Rosefield Solar Farm

Schedule of Changes to the draft DCO (Clean)

EN010158/APP/8.1.8
Revision 08
Deadline 6
August 2026
Rosefield Energyfarm Limited

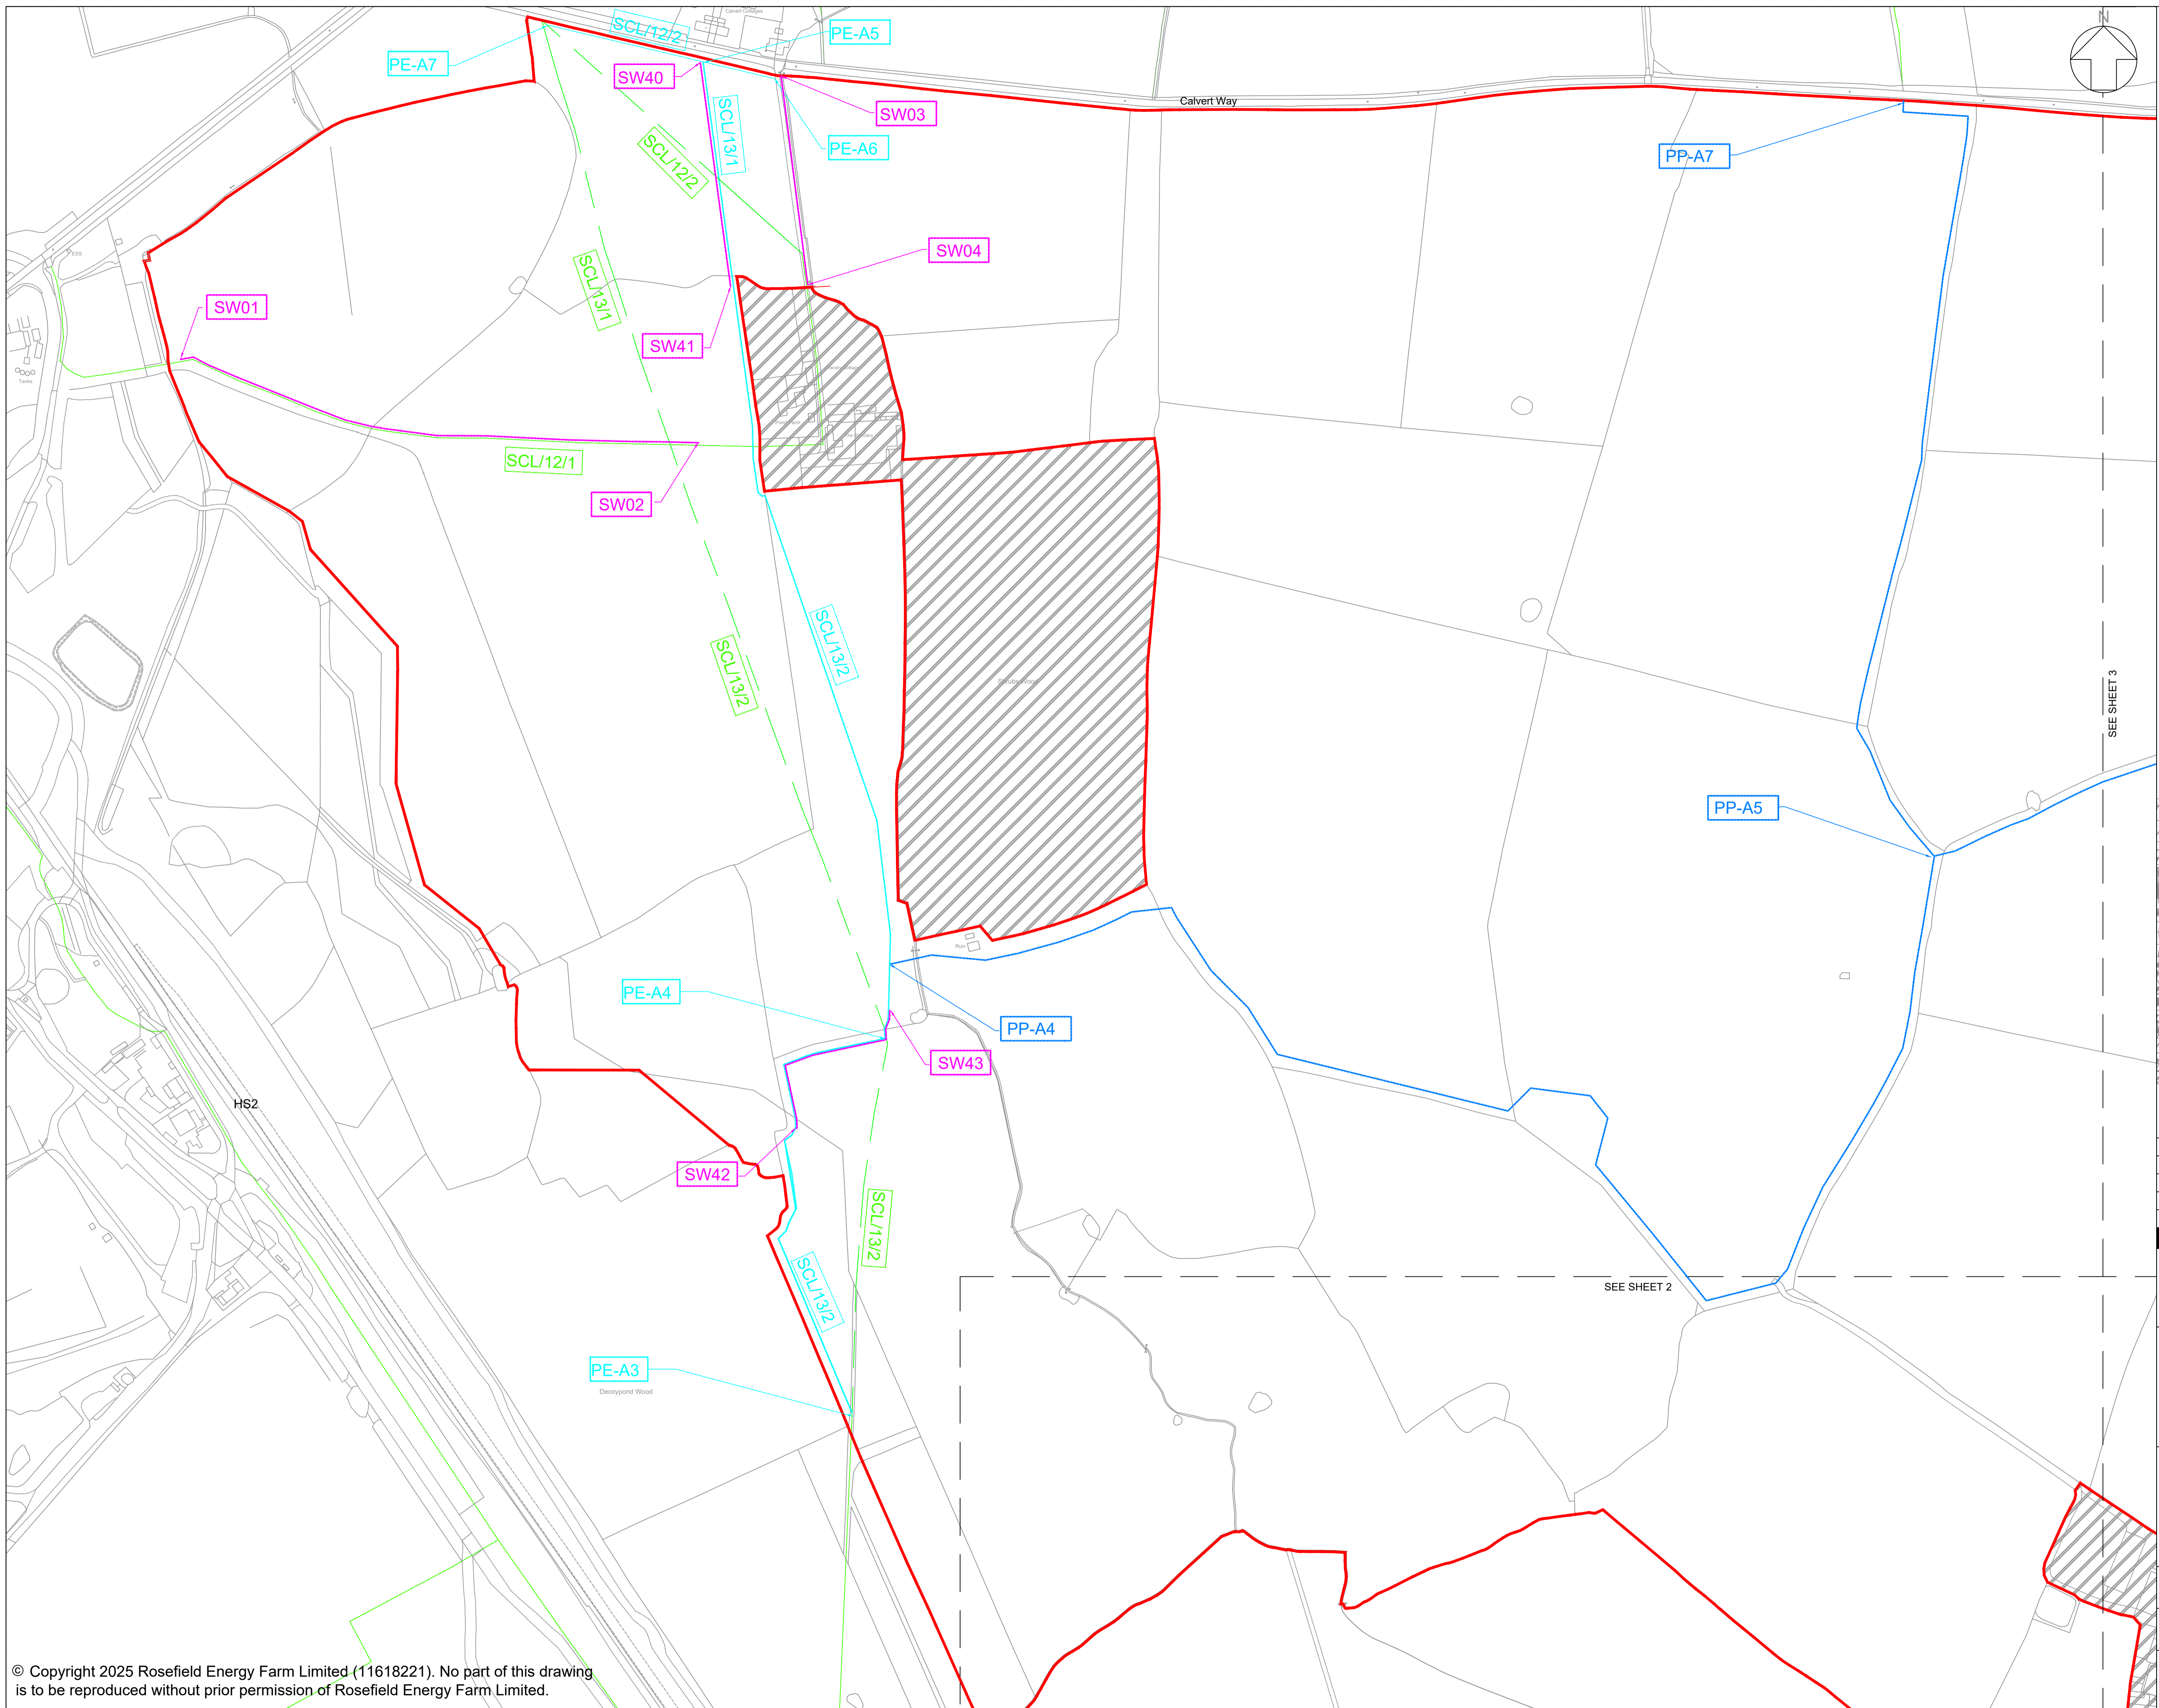
<table><tr> <th>(1) <i>Area</i></th><th>(2) <i>Public right of way to be stopped up</i></th><th>(3) <i>Extent of stopping up</i></th><th>(4) <i>New public right of way to be substituted / provided</i></th></tr><tr> <td>District of Buckinghamshire</td><td>SCL/13/1 and SCL/13/2</td><td>For a distance of 1,210 metres between points PE-A7 and PE-A3 as shown on sheet 1 of the streets, access and rights of way plans.</td><td>New public footpath of minimum width of 2m to be provided between points PE-A7, PE-A5 and PE-A4 and PE-A3 as shown by a cyan line on sheet 1 of the streets, rights of way and access plans.</td></tr><tr> <td>District of Buckinghamshire</td><td>SCL/12/2</td><td>For a distance of 190 metres between points PE-A7 and point PE-A10 as shown on sheet 1 of the streets, access and rights of way plans.</td><td>New public footpath of minimum width of 2m to be provided between points PE-A7, PE-A5 and its intersection with SCL/12/1 as shown by a cyan line on sheet 1 of the streets, rights of way and access plans.</td></tr></table>

(1) <i>Area</i>	(2) <i>Public right of way to be stopped up</i>	(3) <i>Extent of stopping up</i>	(4) <i>New public right of way to be substituted / provided</i>	District of Buckinghamshire	SCL/13/1 and SCL/13/2	For a distance of 1,210 metres between points PE-A7 and PE-A3 as shown on sheet 1 of the streets, access and rights of way plans.	New public footpath of minimum width of 2m to be provided between points PE-A7, PE-A5 and PE-A4 and PE-A3 as shown by a cyan line on sheet 1 of the streets, rights of way and access plans.	District of Buckinghamshire	SCL/12/2	For a distance of 190 metres between points PE-A7 and point PE-A10 as shown on sheet 1 of the streets, access and rights of way plans.	New public footpath of minimum width of 2m to be provided between points PE-A7, PE-A5 and its intersection with SCL/12/1 as shown by a cyan line on sheet 1 of the streets, rights of way and access plans.	In response to Buckinghamshire Council's request in its Local Impact Report [REP1-112] and in engagement with the Council at Issue Specific Hearing 1 where Council requested this be included on the face of the draft DCO.	4
(1) <i>Area</i>	(2) <i>Public right of way to be stopped up</i>	(3) <i>Extent of stopping up</i>	(4) <i>New public right of way to be substituted / provided</i>												
District of Buckinghamshire	SCL/13/1 and SCL/13/2	For a distance of 1,210 metres between points PE-A7 and PE-A3 as shown on sheet 1 of the streets, access and rights of way plans.	New public footpath of minimum width of 2m to be provided between points PE-A7, PE-A5 and PE-A4 and PE-A3 as shown by a cyan line on sheet 1 of the streets, rights of way and access plans.												
District of Buckinghamshire	SCL/12/2	For a distance of 190 metres between points PE-A7 and point PE-A10 as shown on sheet 1 of the streets, access and rights of way plans.	New public footpath of minimum width of 2m to be provided between points PE-A7, PE-A5 and its intersection with SCL/12/1 as shown by a cyan line on sheet 1 of the streets, rights of way and access plans.
